Please upload as consultation for Y/ 50/20/DOC

I attach the plan sent from Bright Plan Civils, with inspection chamber now being a catch pit.

Y/50/20/DOC at Rookery Cottage.

Drawing Status	FOR APPROVAL
Client	Lara Mackendrick
Project	Rookery Cottage, Hoe Lane Flansham, Bognor Regis PO22 8NT
Drawing Title	Engineering Layout - Drainage & Level Design
Scale	VARIES
Date	May '20
Drawn By	DJL
Checked By	LDL
Drawing No.	D1828-002
Rev.	-

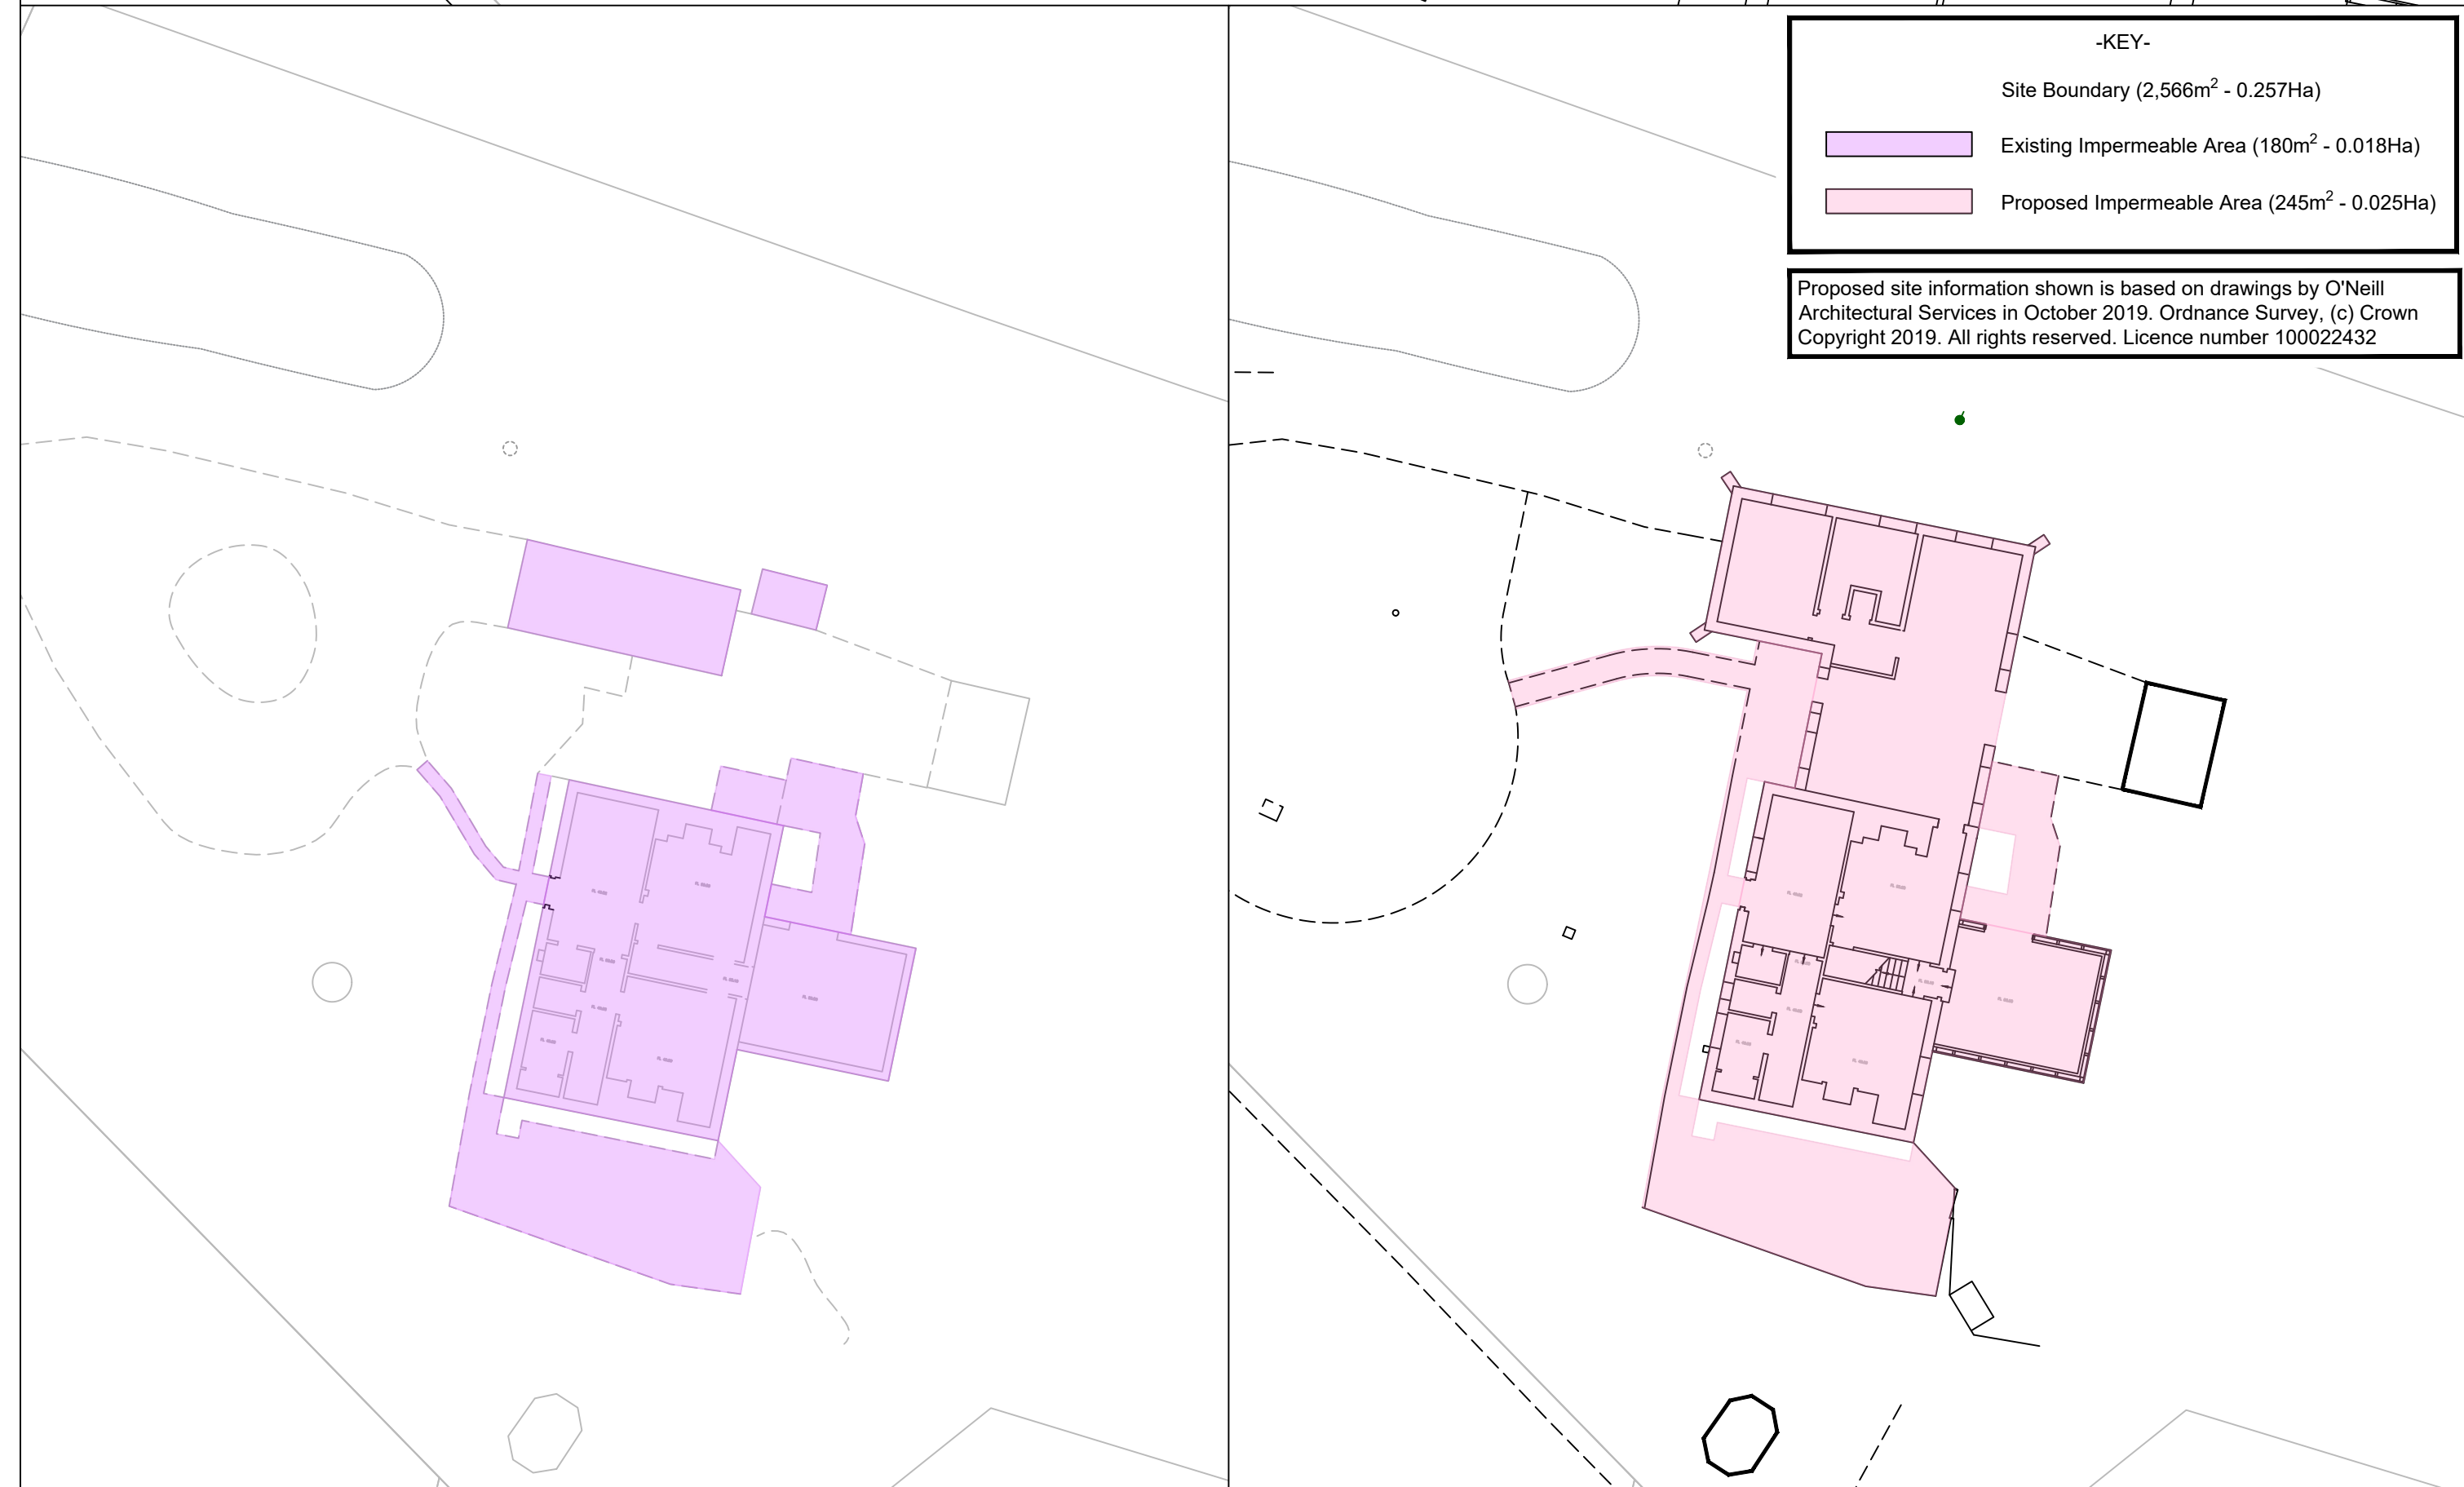
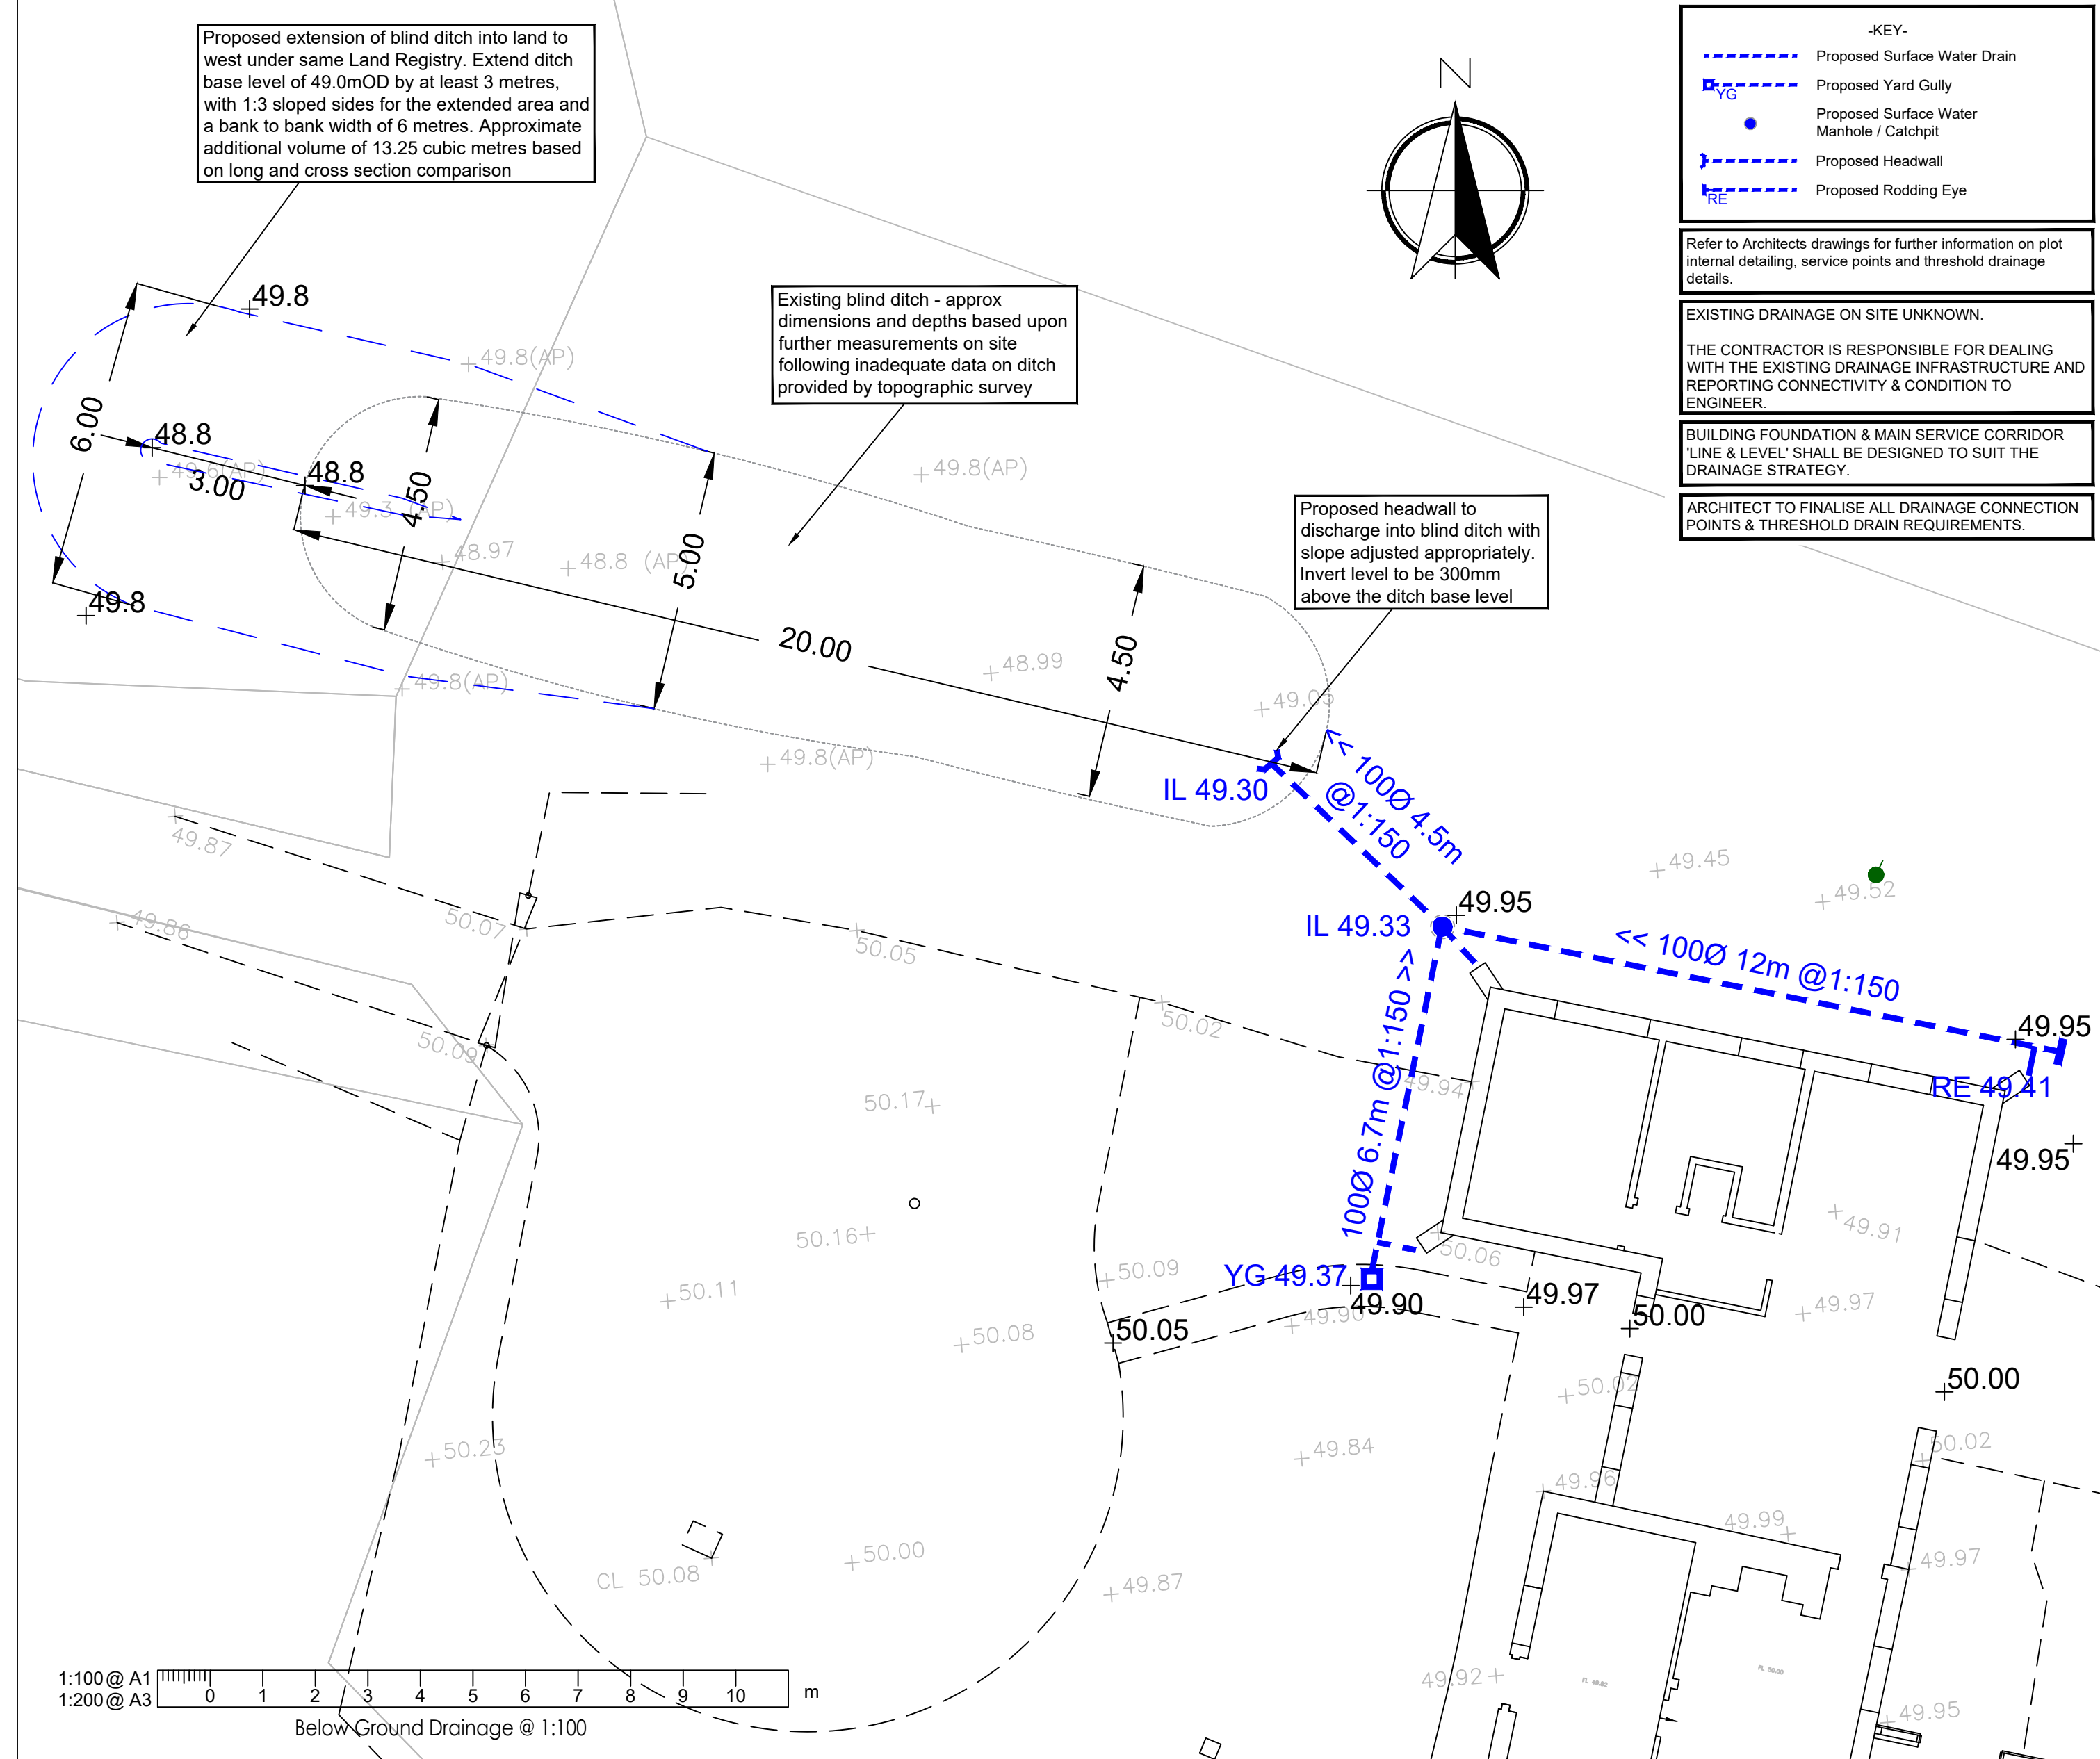
'Please amend the inspection chamber to a catch pit (provide a sump). Once this is done I will be happy to recommend discharge of condition 3'.
